From: **Marc Daley** <Marc.Daley@environment.nsw.gov.au>
Date: Tue, Sep 8, 2020 at 11:00 AM
Subject: RE: Moonee SSD 7198
To: Jason Wasiak <jason@jwplanning.com.au>
Cc: Emma Butcher <Emma.Butcher@planning.nsw.gov.au>, Krister Waern
<krister.waern@environment.nsw.gov.au>

From: Jason Wasiak <jason@jwplanning.com.au>
Sent: Monday, 7 September 2020 3:22 PM
To: Marc Daley <Marc.Daley@environment.nsw.gov.au>
Cc: Emma Butcher <Emma.Butcher@planning.nsw.gov.au>; Eric Fuller <e.fuller7@icloud.com>; Kerry Albert <kerry.albert@uniteadvisory.com.au>
Subject: Moonee SSD 7198

Subject: RE: Moonee SSD 7198

**Peak Water Level – 1 in 100 Year ARI With Climate Change.  
Moonee Creek Flood (Scenario 5) Developed Conditions**

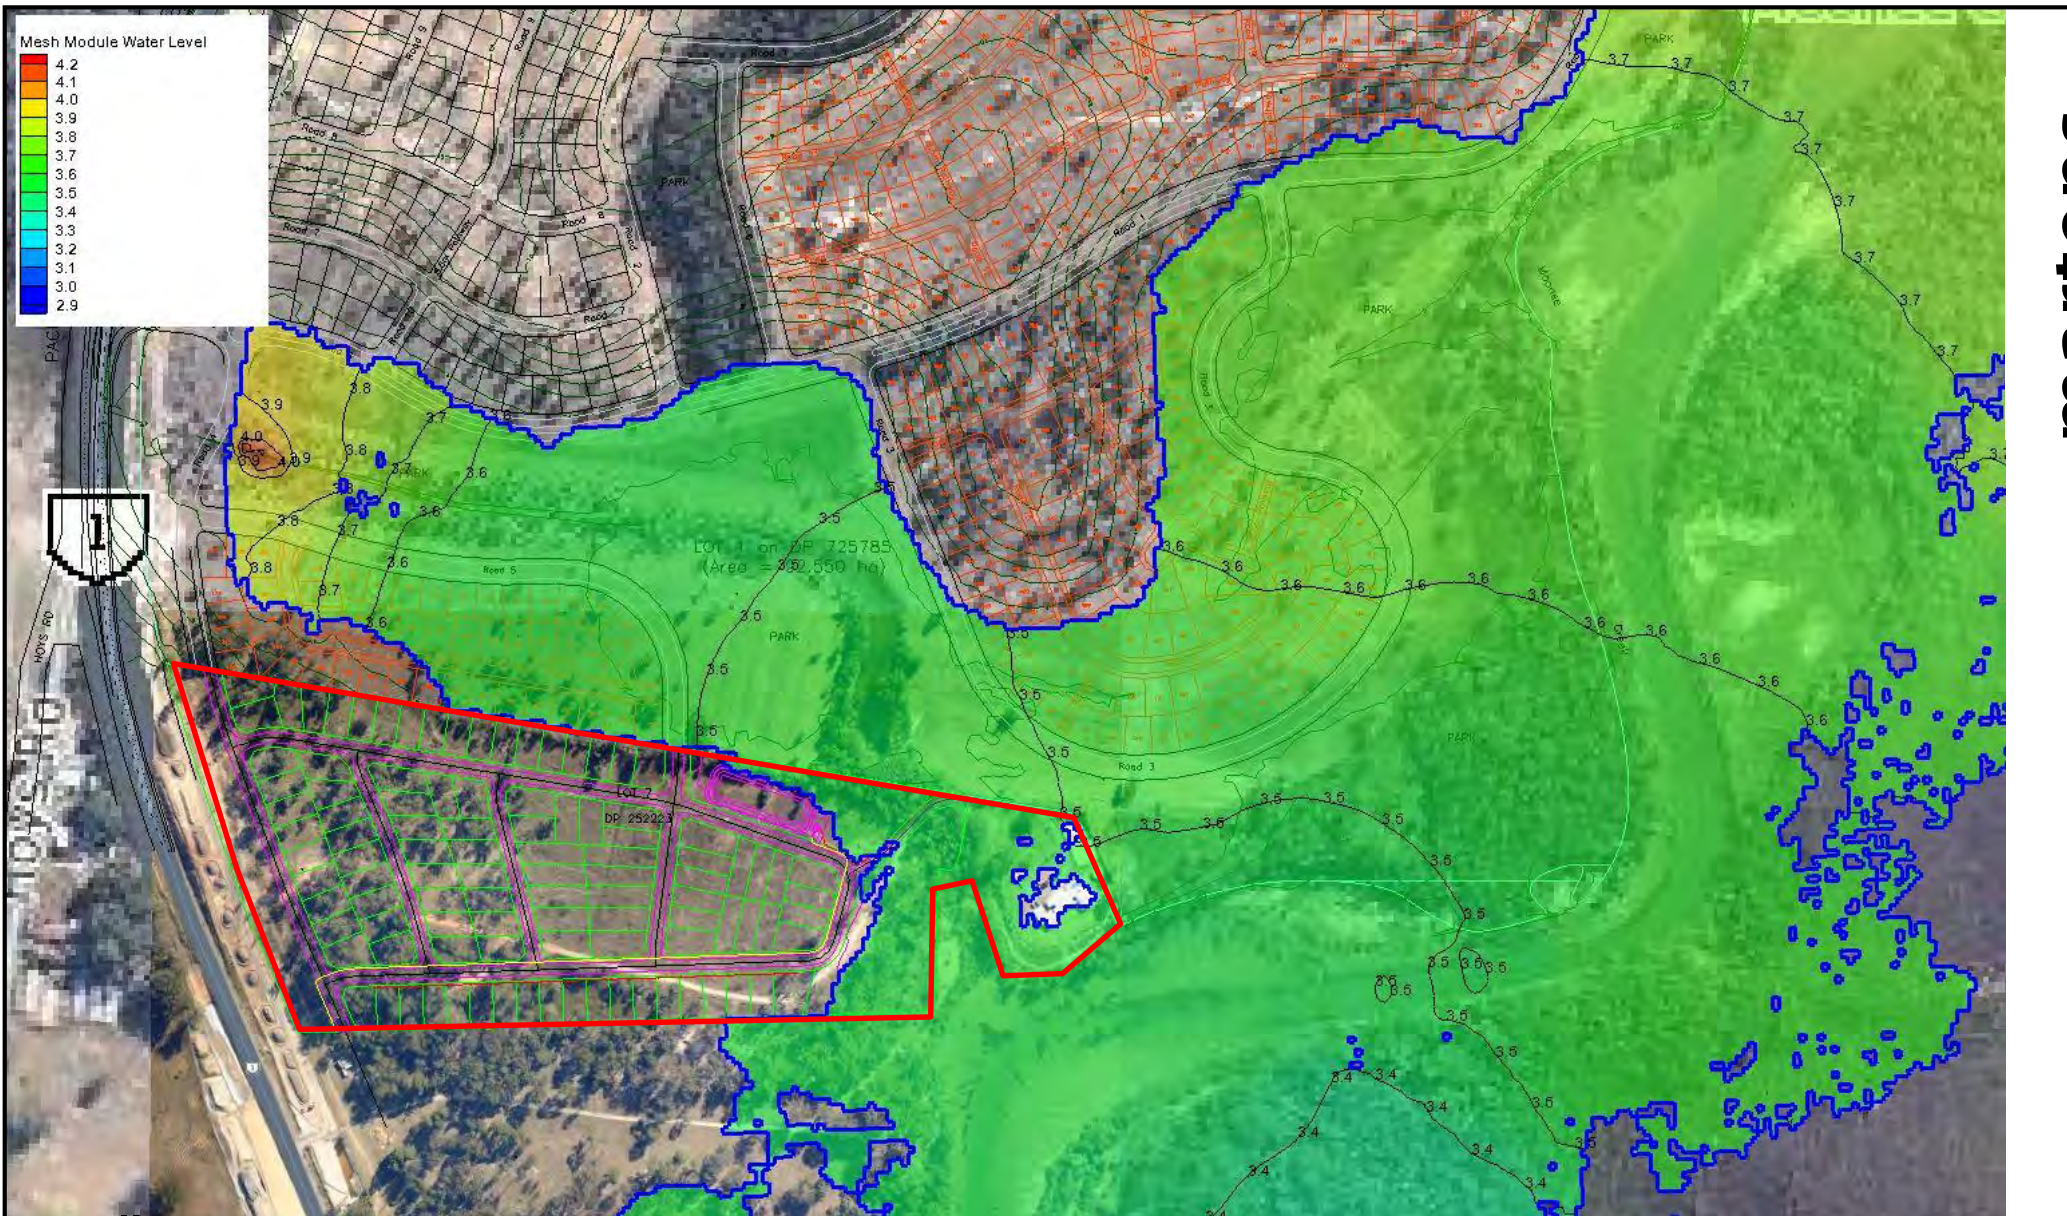
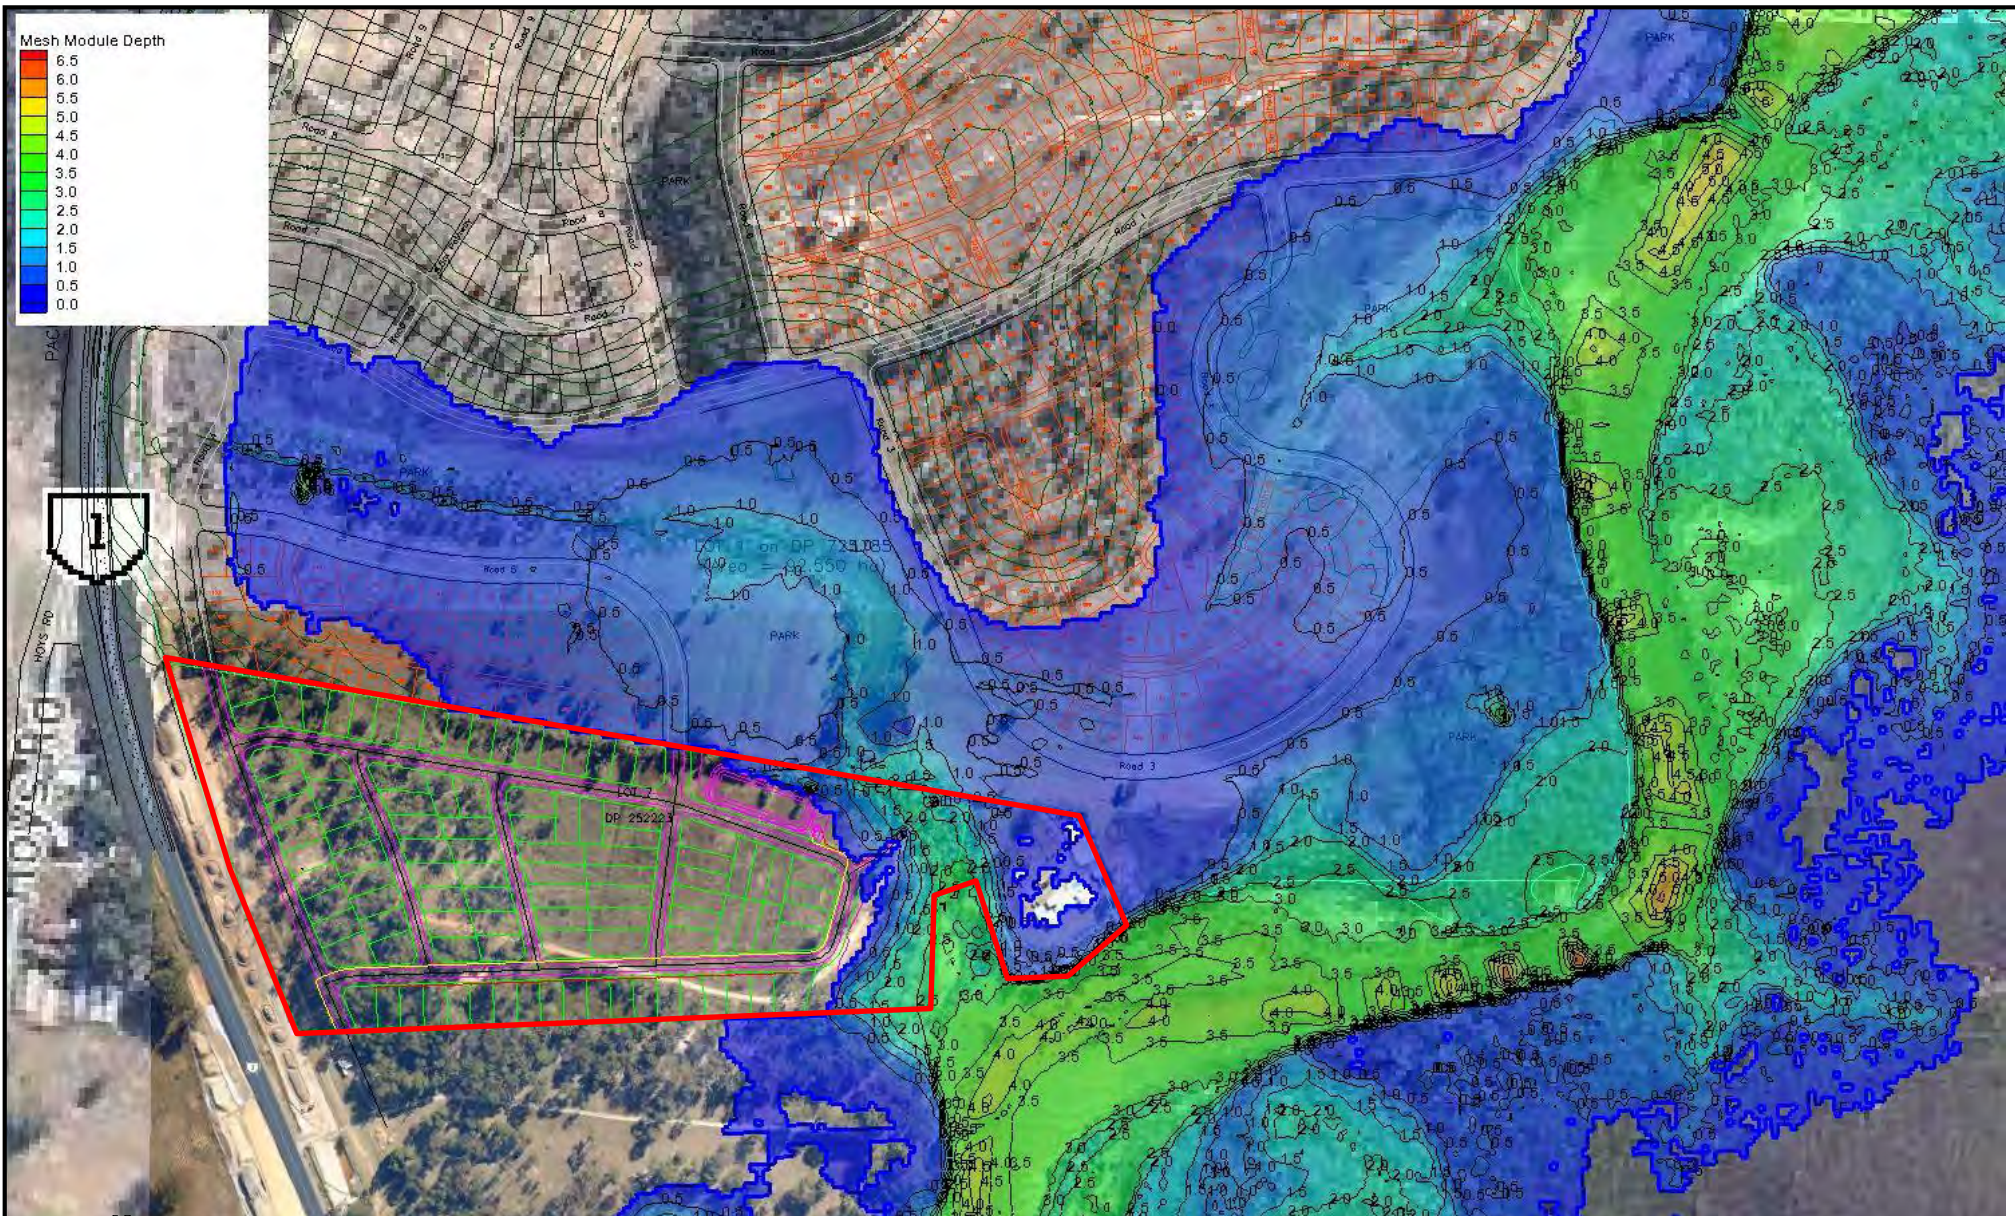
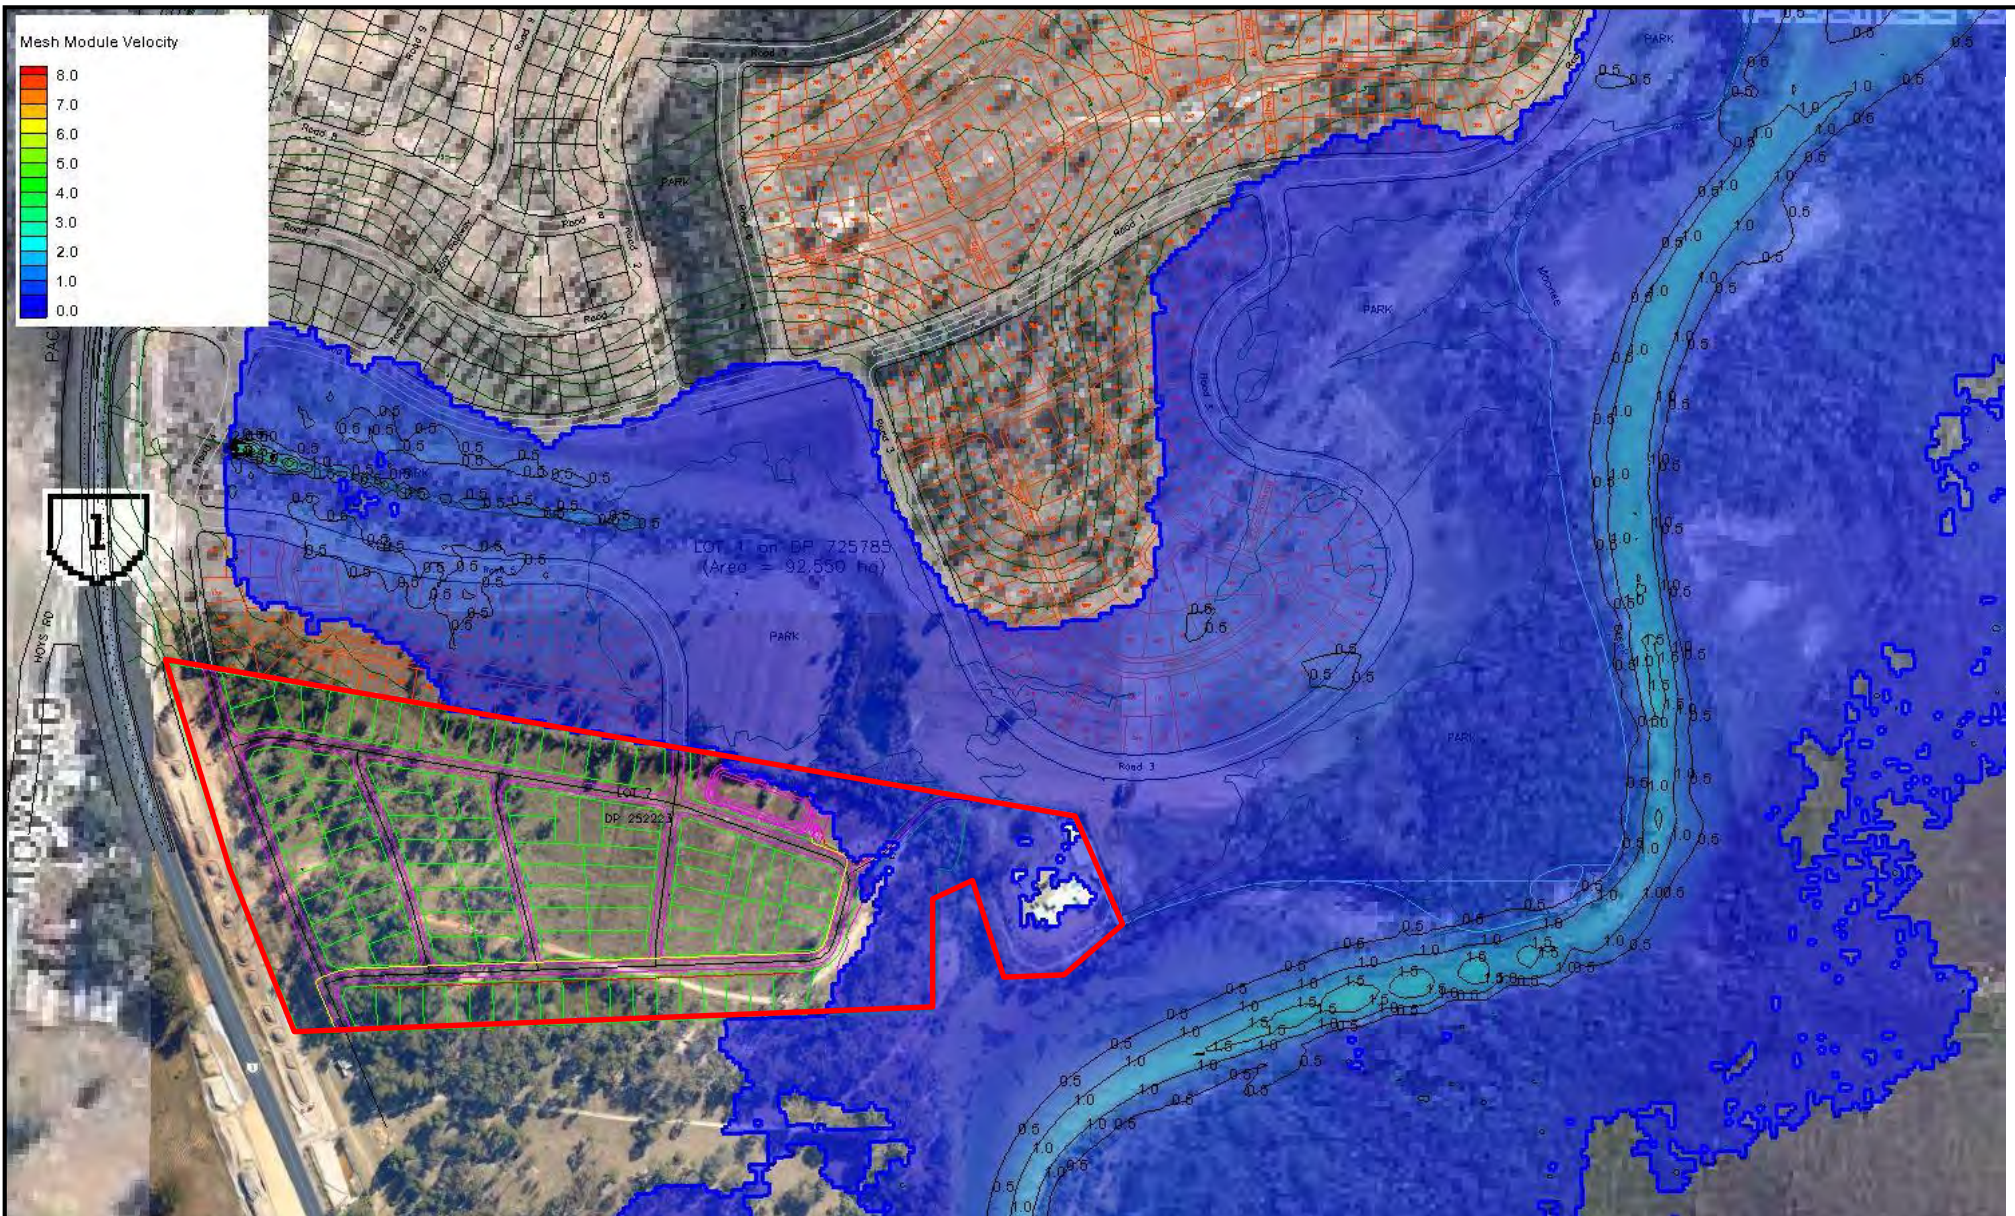
Please note the request wasn't for a 1% AEP flood and 1% AEP ocean water level to occur concurrently, per Jeff's reply. Only that proper consideration has been given to the tidal inundation through the ocean water level component, including the future impacts of projected climate change. From the flood modelling report initially provided, though scenarios 5 and 10 were listed, it wasn't clear how these scenarios were determined and the considerations given in relation to the ocean water boundary.

He is seeking clarification as to whether tidal inundation was included in the flood modelling. He said it was unclear from the data within the Marten's report.

He suggests that normally a 1% ocean water level + Sea Level Rise is factored into modelling, but believes this may not have been necessary if local catchment flooding is equal to or greater than ocean water flood level. Does this make sense to you, and can you please call me to discuss ASAP?

With reference to Section 3.2.3 of our flood assessment report, we have run various flood modelling scenarios. The worst case scenarios (5 and 10 in our report) assessed a 1% AEP flood with a 5% AEP climate change ocean level plus climate change of 0.91m (being 3.01 mAHD).

The BCD request for modelling a 1% ocean level plus 0.91m is contrary to the above. It also differs from the previous advice and discussions that we had with Council and WBM (experts acting on behalf of the Council). We note that applying BCD's request would mean modelling a very rare event, given that the 1% events for the flood and the inundation would need to occur concurrently. I expect this is why the various department guidelines noted above do not require such events to be modelled for design.

In light of the above, our flood assessment is considered satisfactory to assess impacts from tidal inundation and not further modelling is considered necessary.
